CITY OF ALBUQUERQUE

December 14, 2023

**RE: North Domingo Baca Aquatic Center
Grading & Drainage Plans
Engineer's Stamp Date: 09/18/23
Hydrology File: C19D043E**

Based upon the information provided in your submittal received 11/14/2023, the Grading & Drainage Plans **are not** approved for Building Permit and Grading Permit. The following comments need to be addressed for approval of the above referenced project:

A1 GRADING PLAN
1" = 30'-0"

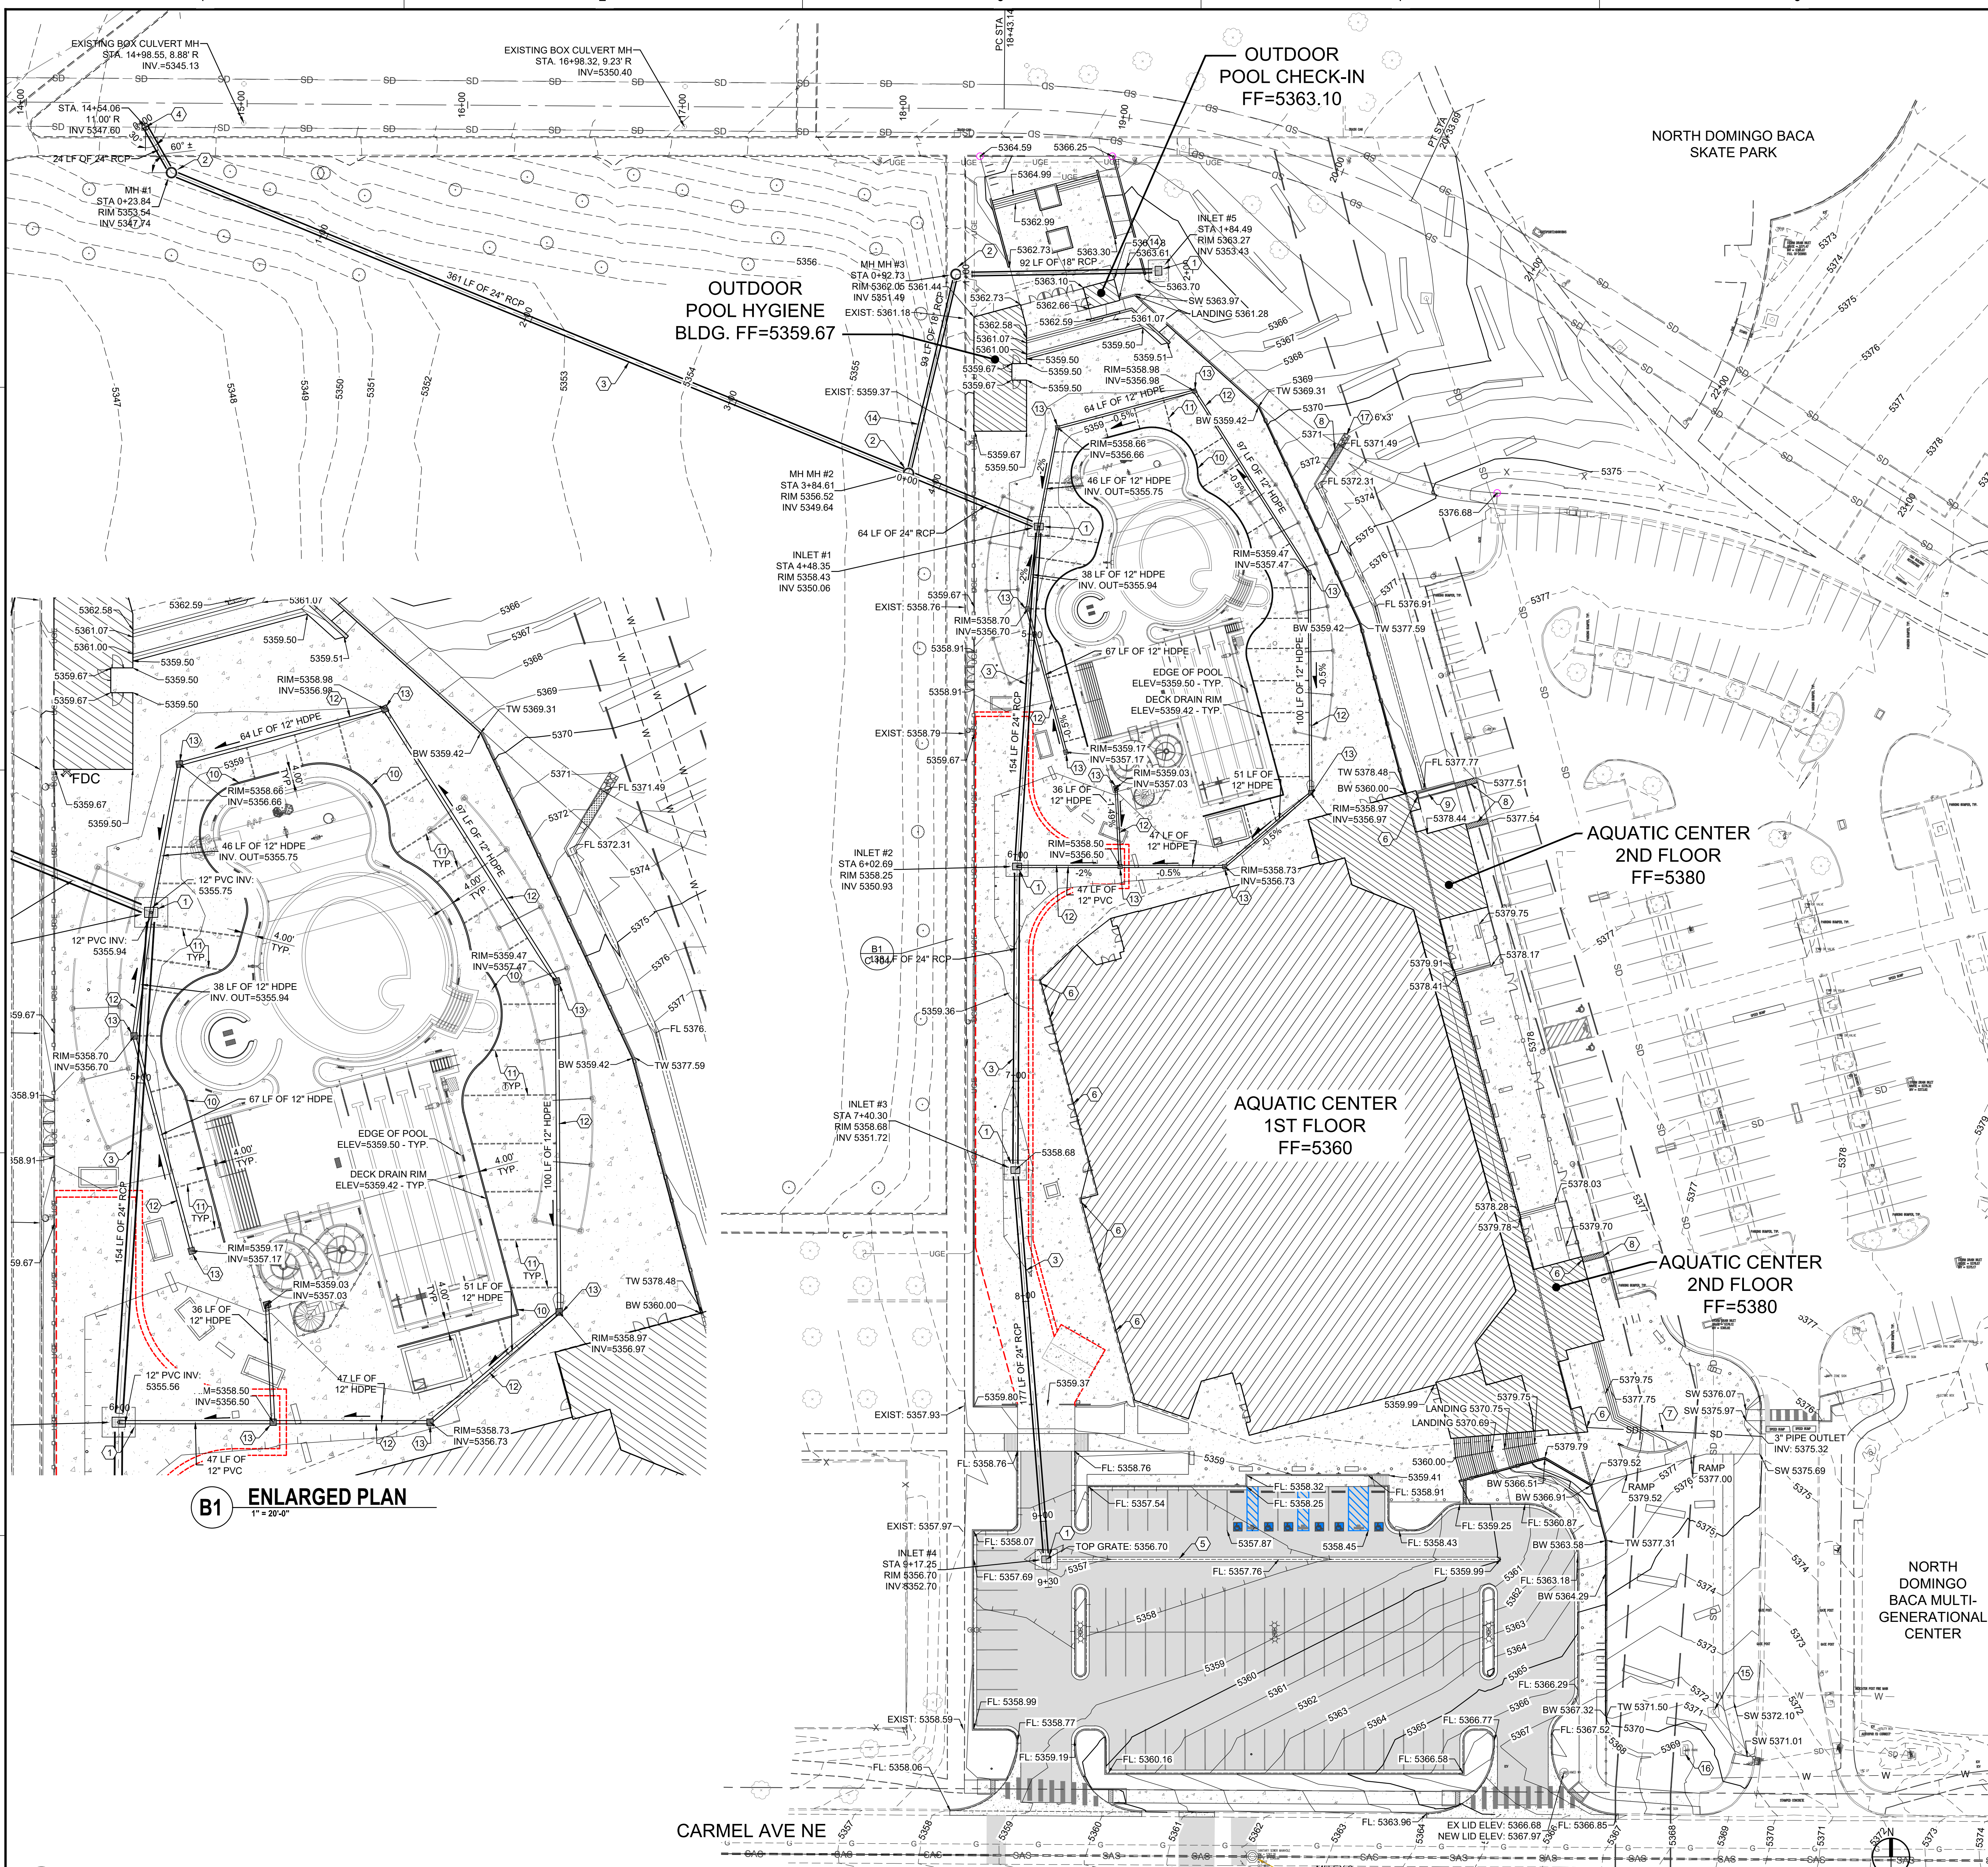
- The Flood Zone section states that the BFE is 5320' for the AO1 flood zone. Where was this BFE derived? The site is largely at an elevation of ~5360. Verify or revise the BFE.
- Provide the hydrology calculations for the existing and proposed basins.
 - The proposed basins should be divided based on the proposed drainage infrastructure to ensure that the infrastructure is sized appropriately.
- Provide the hydraulic calculations for the proposed storm drain infrastructure on-site (inlet sizing, storm drain, etc.).
- Verify that there is capacity in the existing CBC for an additional pipe penetration.
 - The storm drain calculations should assume the max HGL in the CBC as the tailwater condition for the system.

HYDROLOGY

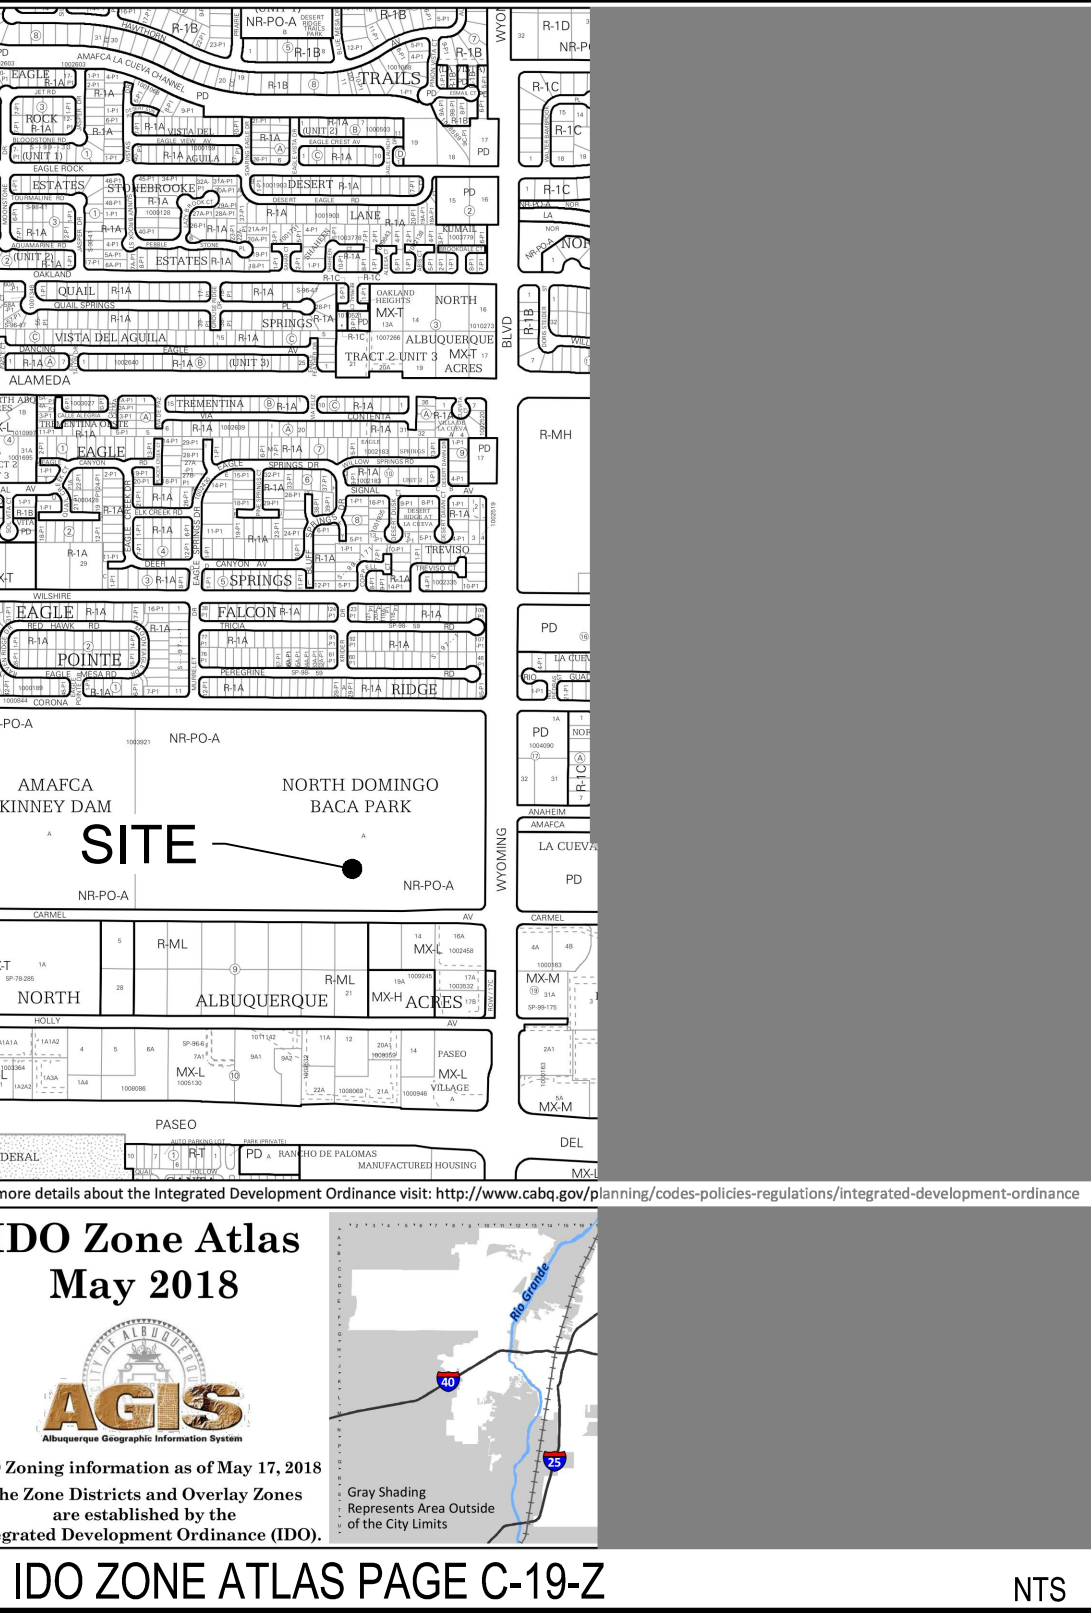
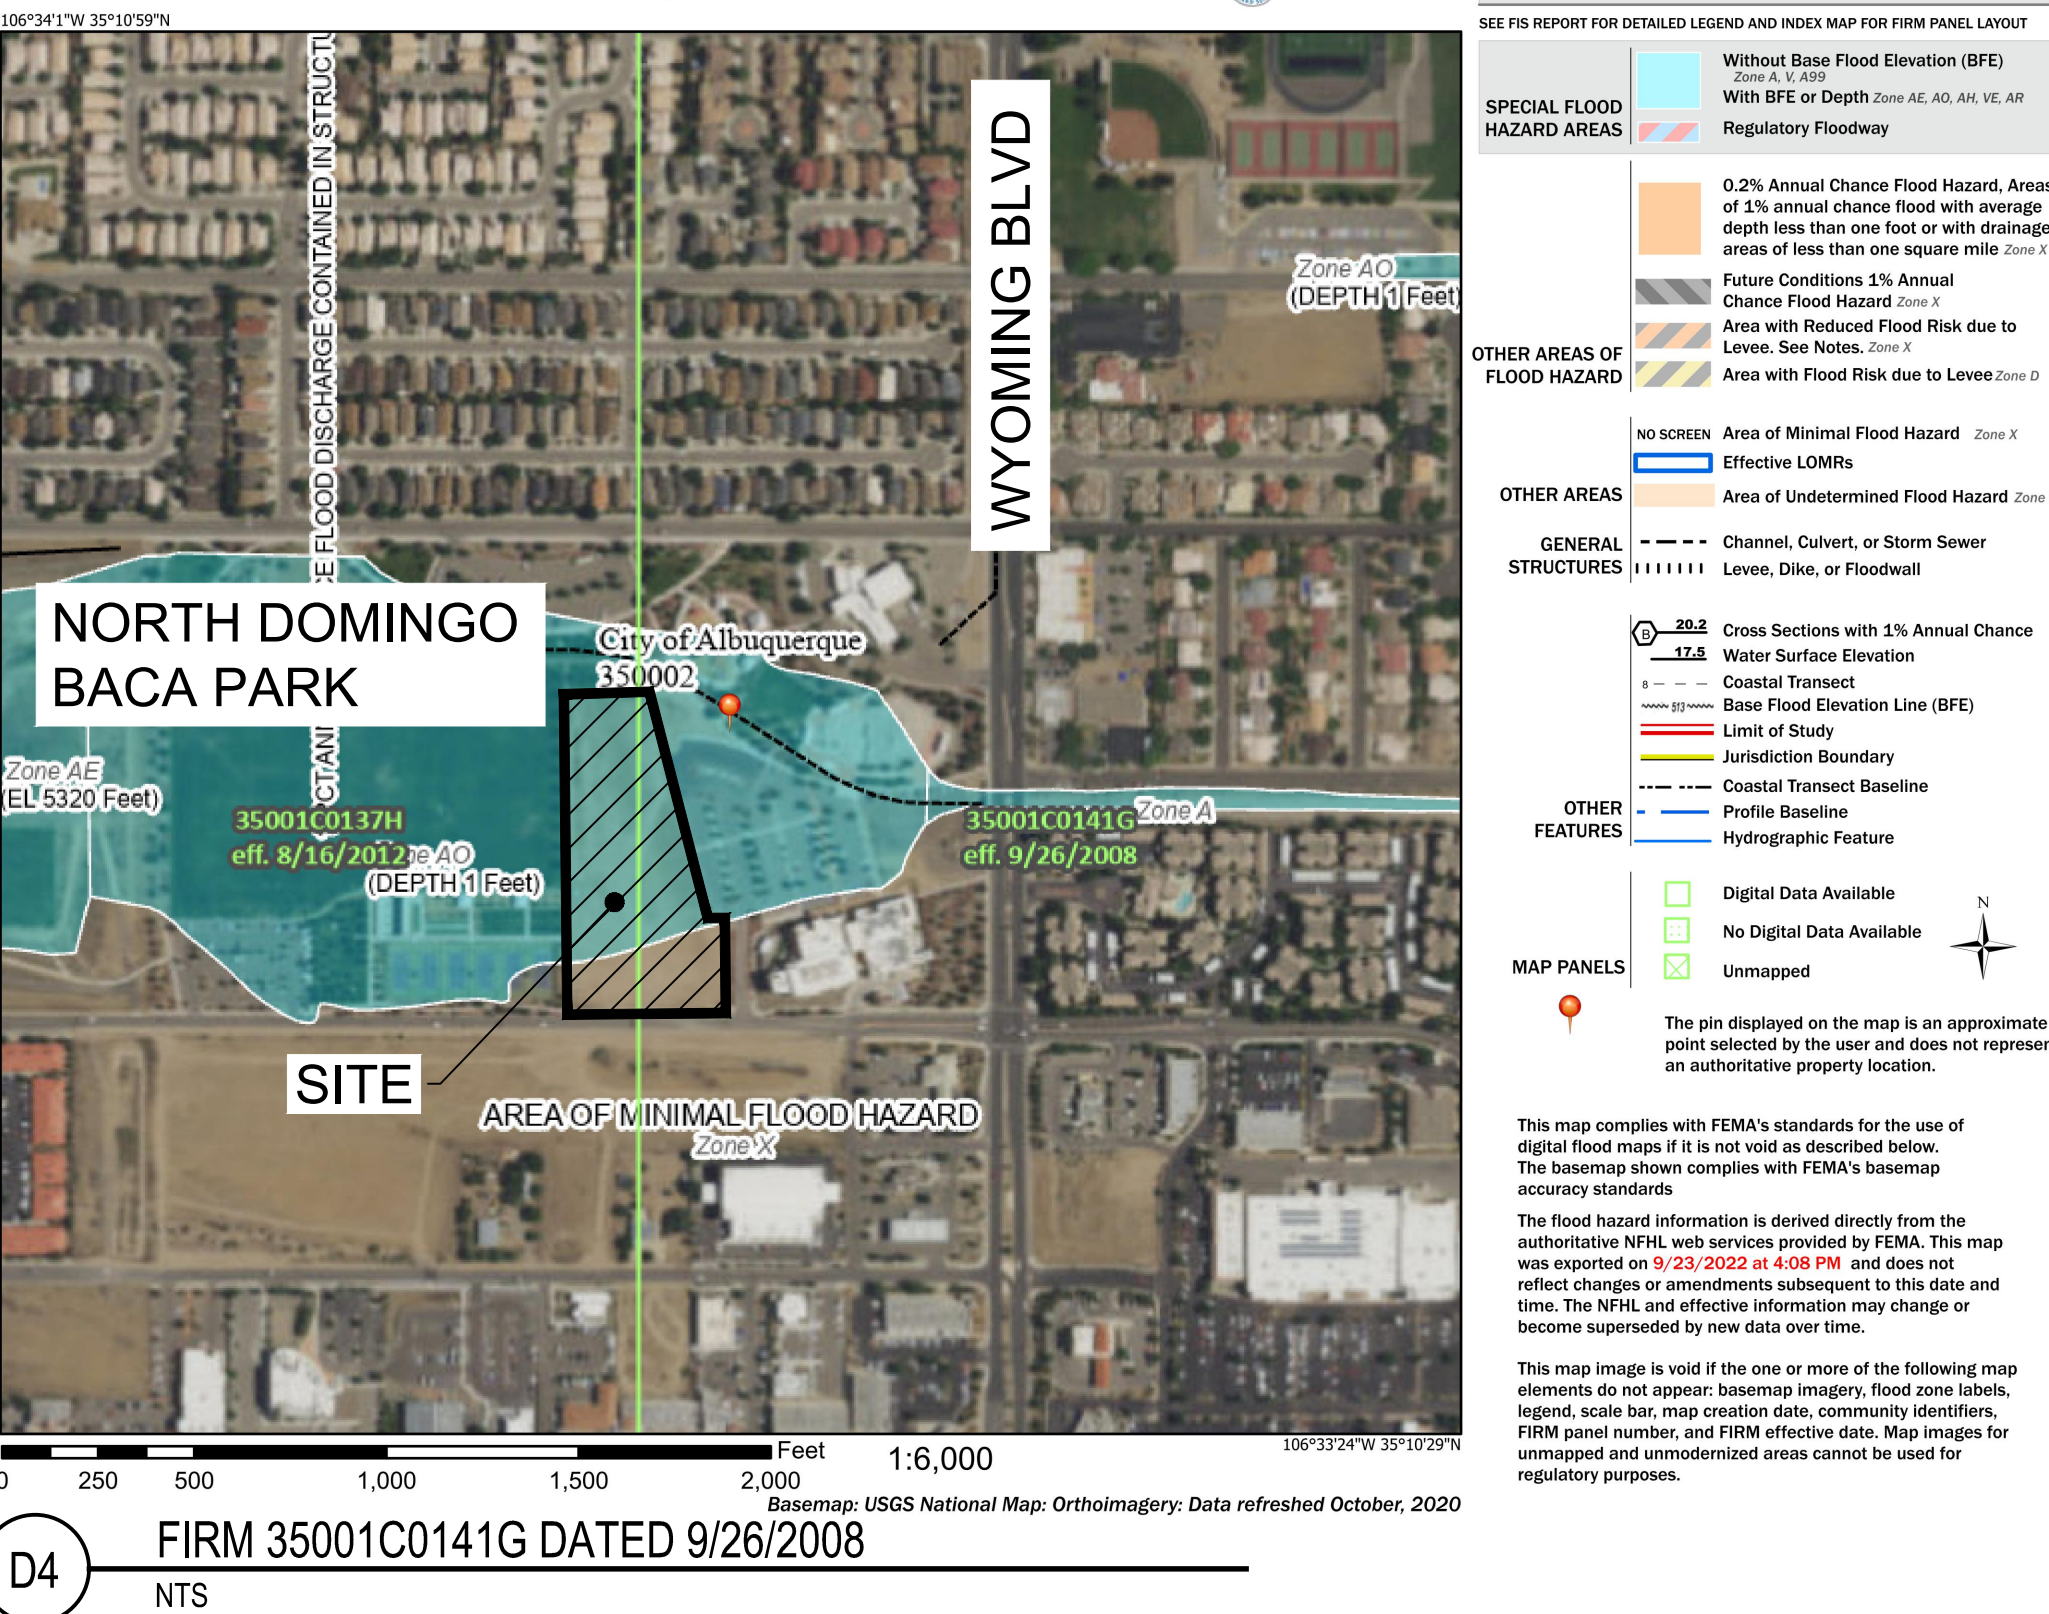
1. Since this project is adjacent to, or drains into an Albuquerque Metropolitan Arroyo and Flood Control Authority (AMAFCA) facility, approval by AMAFCA will be needed prior to Hydrology approval. Please contact Jared Romero P.E, CFM (jromero@amafca.org or 505-884-2215).
2. **Drainage Plan – C110.** Under the Existing Conditions, please add the existing discharge rate.

THIS SITE IS UNDER THE NORTH DOMINGO BACA MASTER PLAN AND DISCHARGES TO THE MCKINNEY DAM. STORM WATER FACILITIES ARE EXISTING AND SIZED FOR STORMWATER FLOWS ATTRIBUTABLE FROM THIS PROJECT. EXISTING CONDITIONS SITE DISCHARGE RATE IS ____ CFS.

3. **Drainage Plan – C110.** Under the Flood Zone, it states that the flood zone is AO with a 1' depth inundation. Then it states that the Base Flood Elevation is 5320. How was this determined? North Domingo Baca is about elevation 5388 at the eastern property line along Wyoming Blvd and about 5332 at the western property line.
4. **Drainage Plan – C110.** Under the Proposed Conditions, please state that a LOMR will be submitted to FEMA to remove the flood zone AO from the property prior to Permanent Certificate of Occupancy.
